Letter No.C 4/12078/2003

Sub: CMDA - Planning permission - Proposed
construction of office Building for Tamil
Nadu State Wakf Board at R.S.No.4107, Block
No.36, V.O.C. Nagar, Chennai. Development
Charges and other charges to be remitted
- Regarding.

SITE PLAN

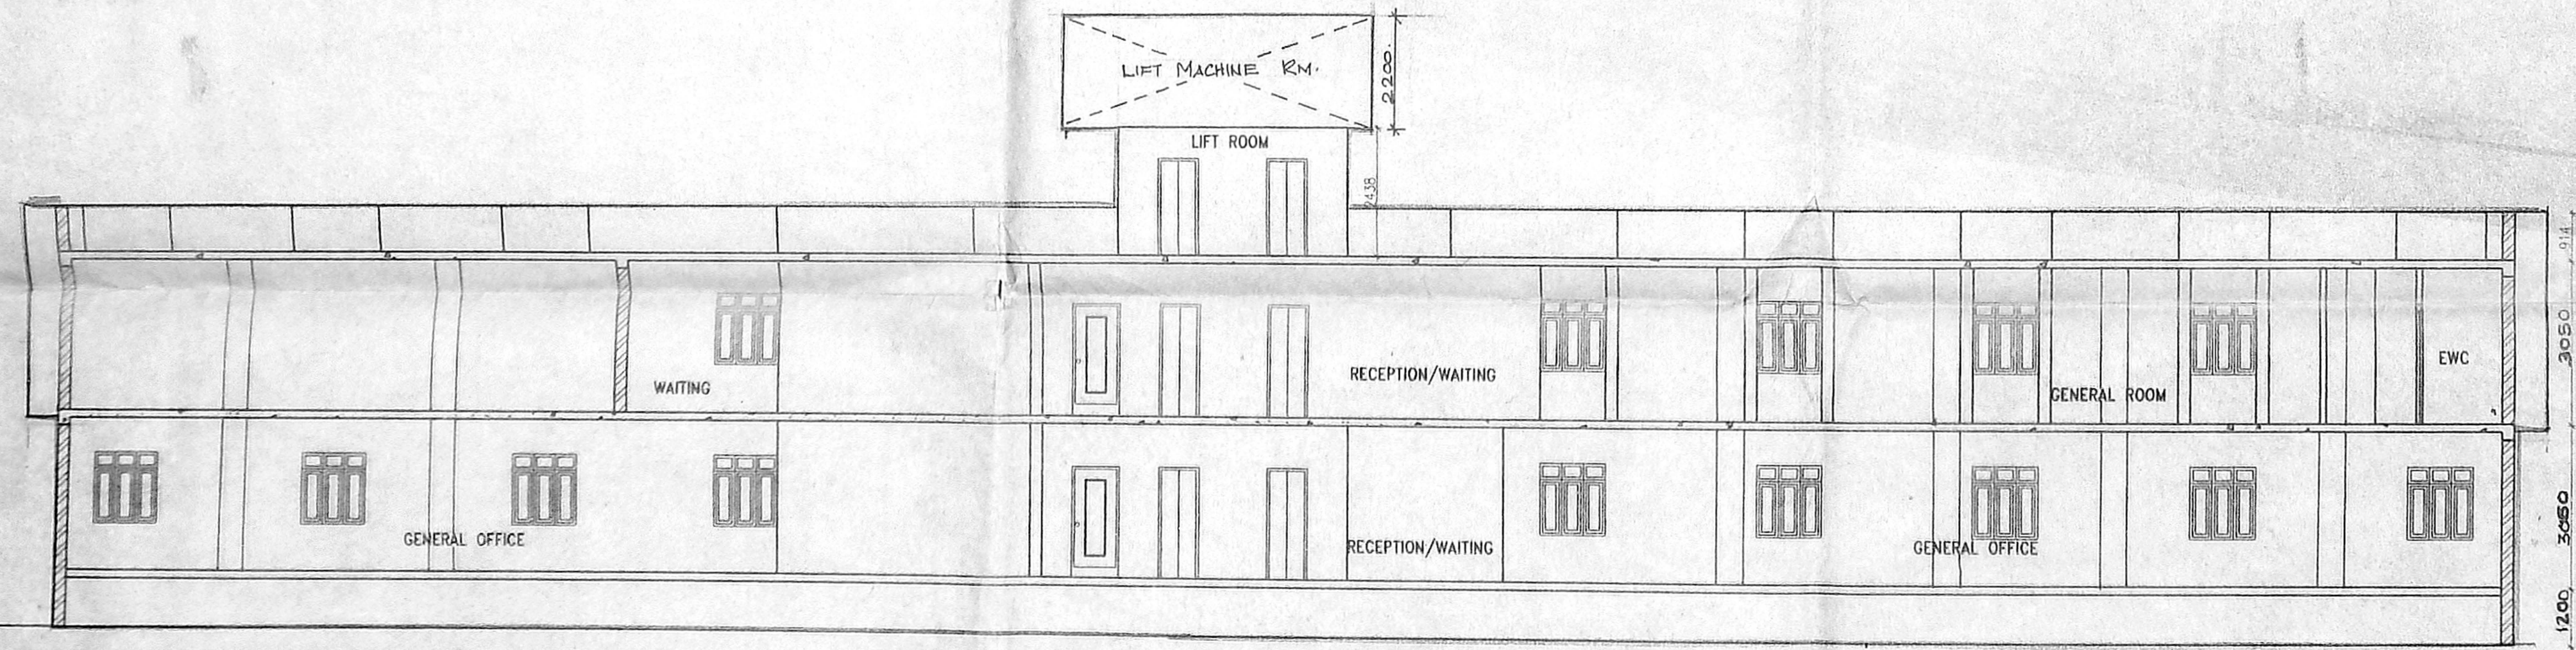
- a) Rain water conservation measures notified by CMDA should be adhered to strictly.
- b) **plot extent wrongly shown in the plan.**
- c) **Lift machine room staircase not shown in the terrace floor plan.**
